Response to Planning application from Hertfordshire County Council (T and CP GDP Order 2015)

District ref: 6/2021/3401/MAJ
HCC ref: WH/11567/2022
HCC received: 23 March 2022
Area manager: Matthew Armstrong
Case officer: Chris Carr

OCADO LTD GYPSY MOTH AVENUE HATFIELD AL10 9BD

Installation of 3,536 solar photovoltaic (PV) array and all associated hardware on existing roof.

TITLE **SOLAR PANEL LAYOUT MARKUP**

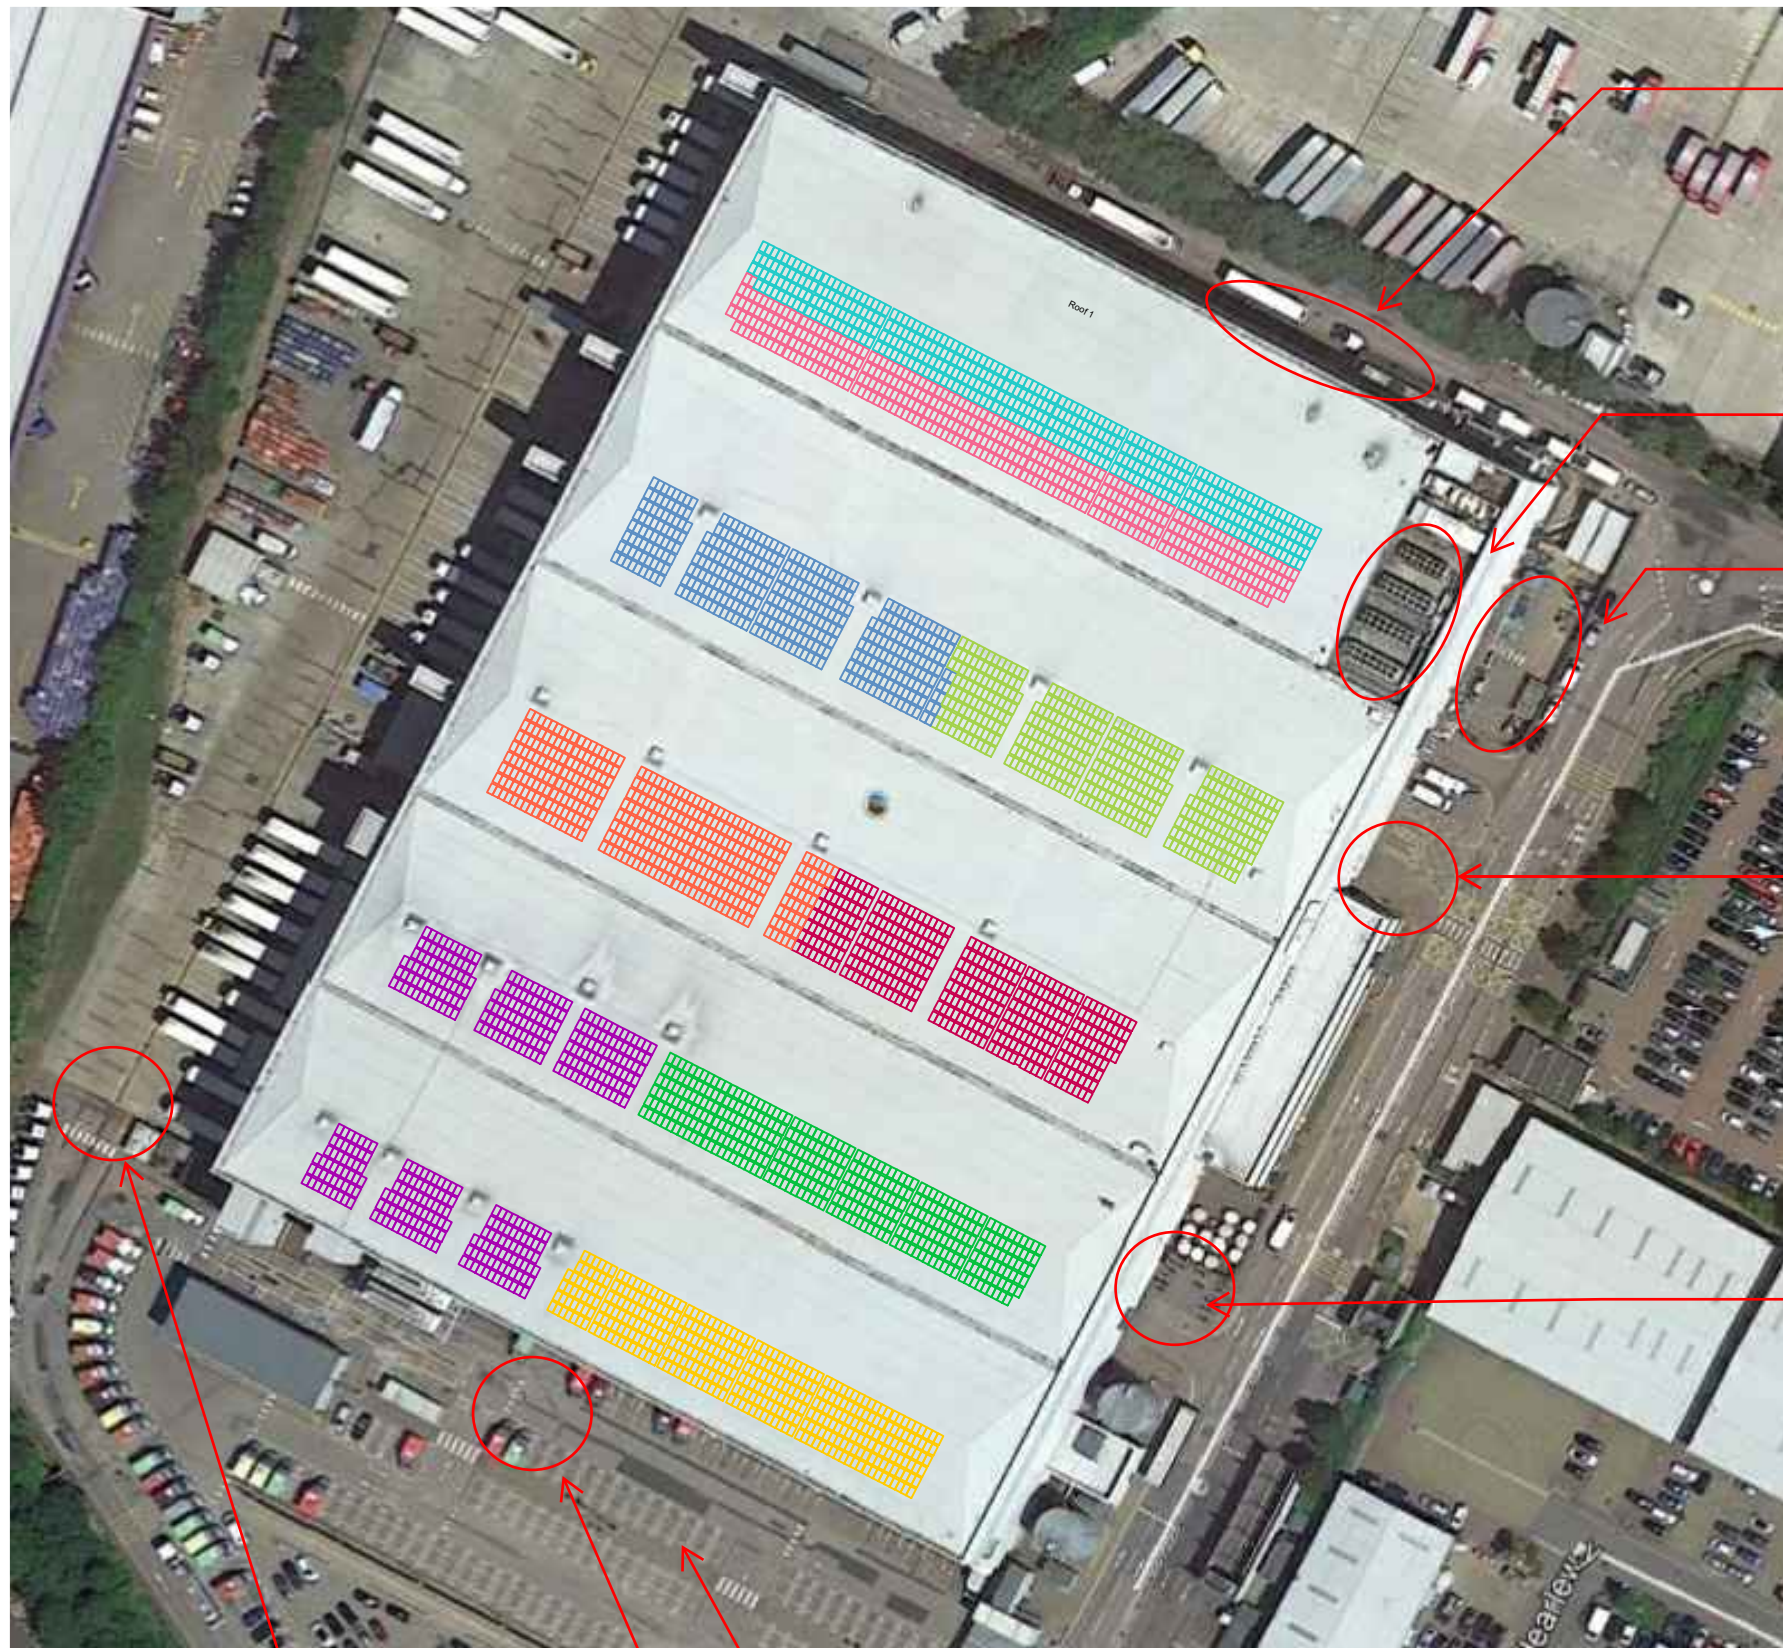
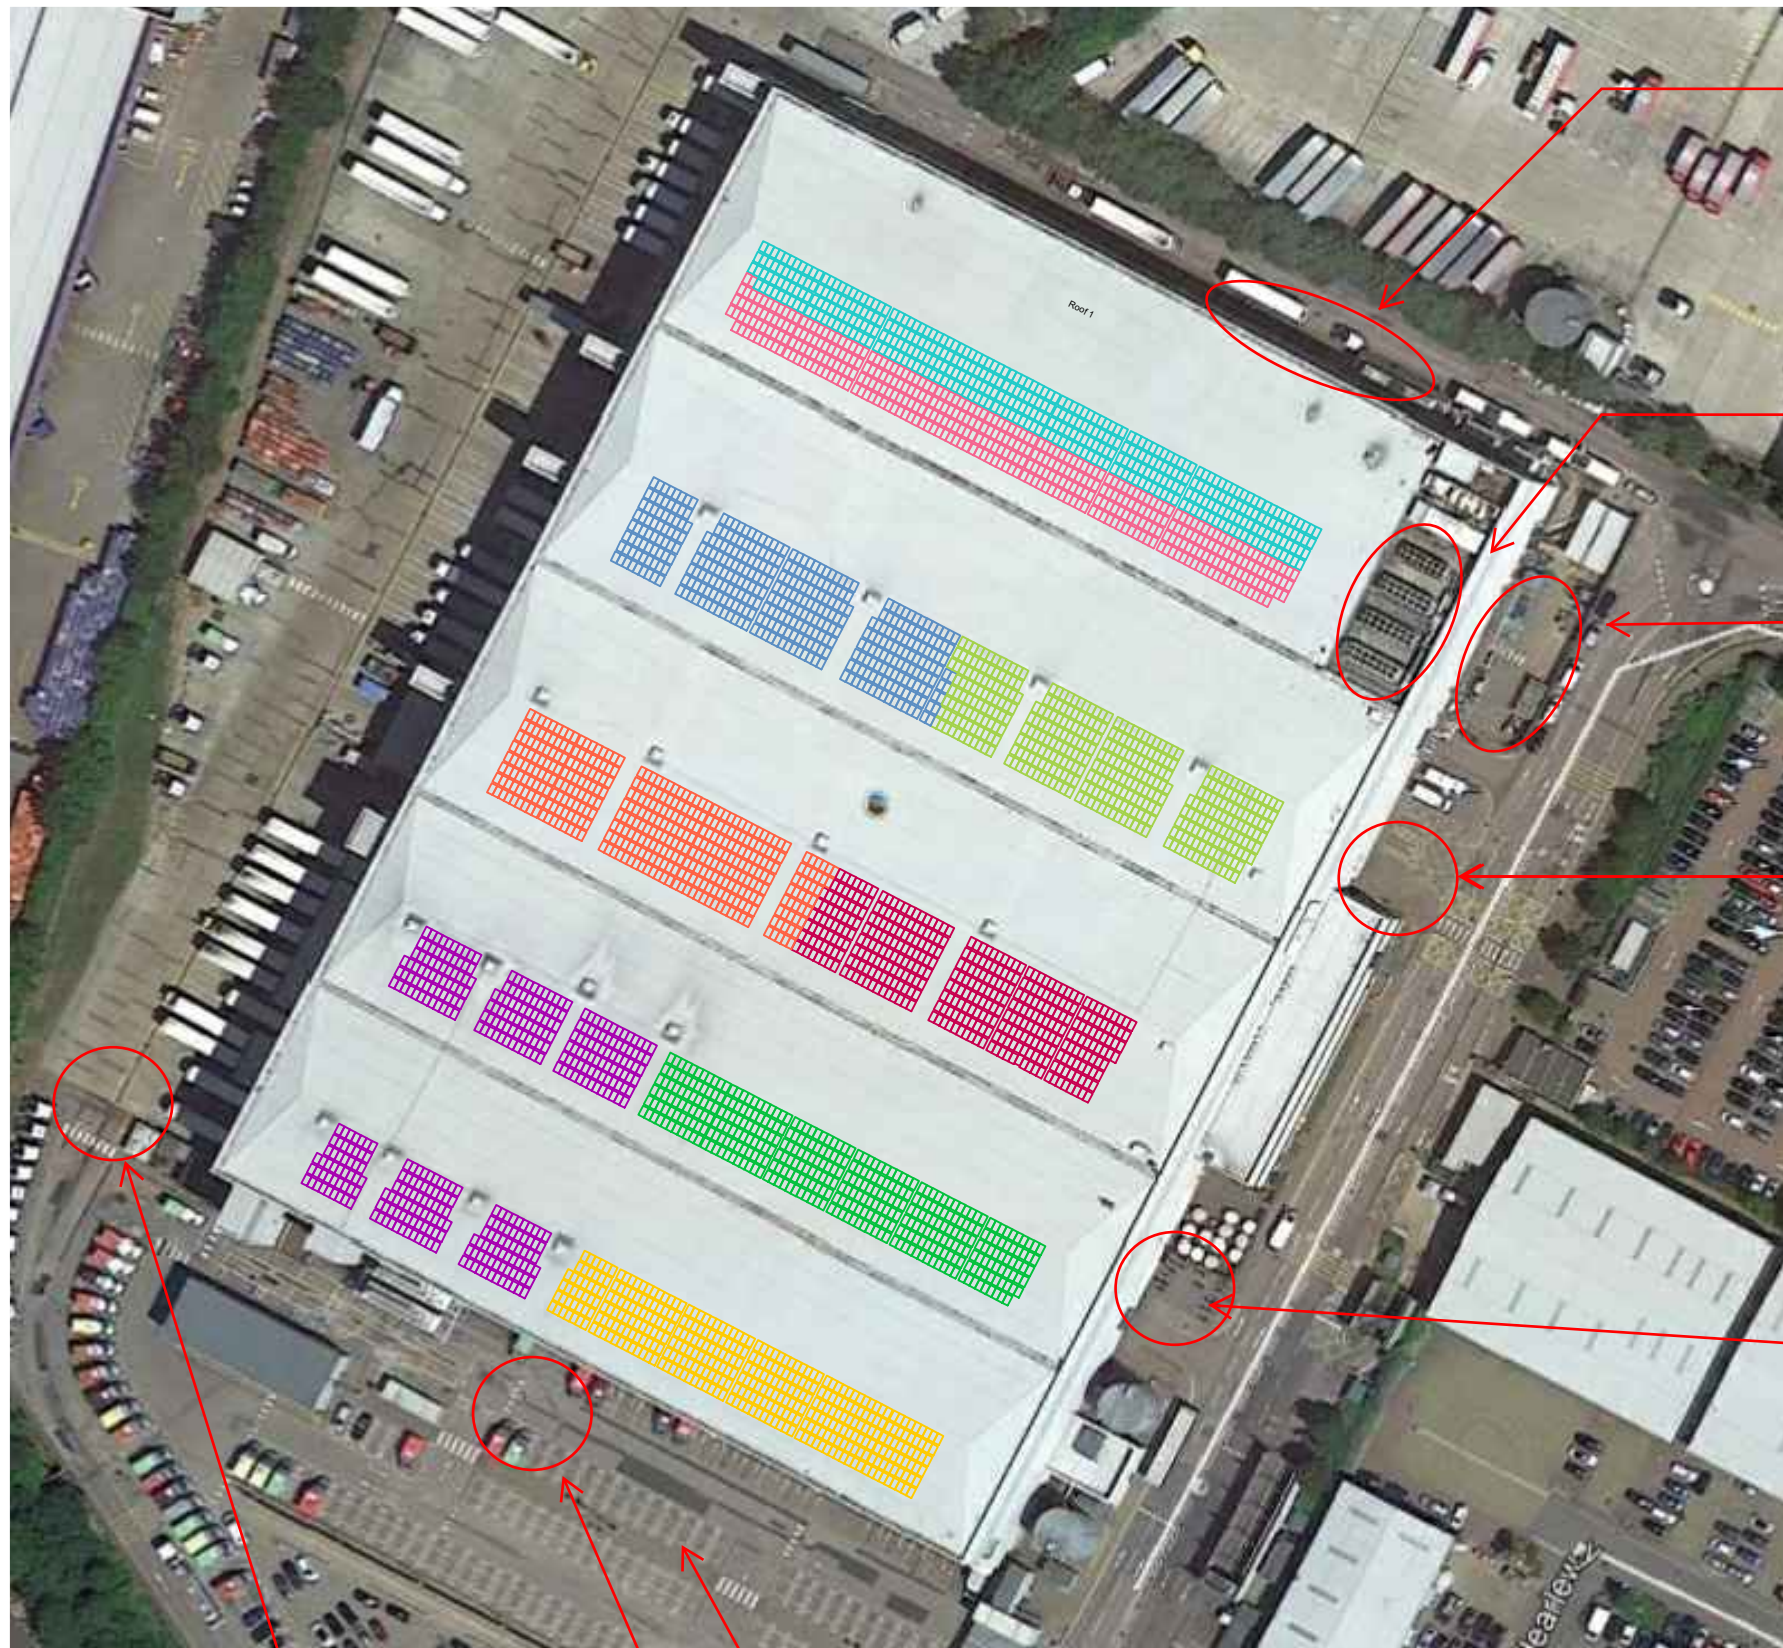
- Further information must be provided regarding the proposed Ocado staff car parking relocation.

The site currently comprises of a commercial unit and associated car parking section 4.8.3 of the DAS states the staff parking for the site will be relocated for the duration of the works. Further information must be given such as details of quantity of current and proposed parking spaces, the vehicular route to the parking spaces, and route by foot from the parked car to the building entrances. HCC Highways is awaiting this information before this application may be accepted or rejected.
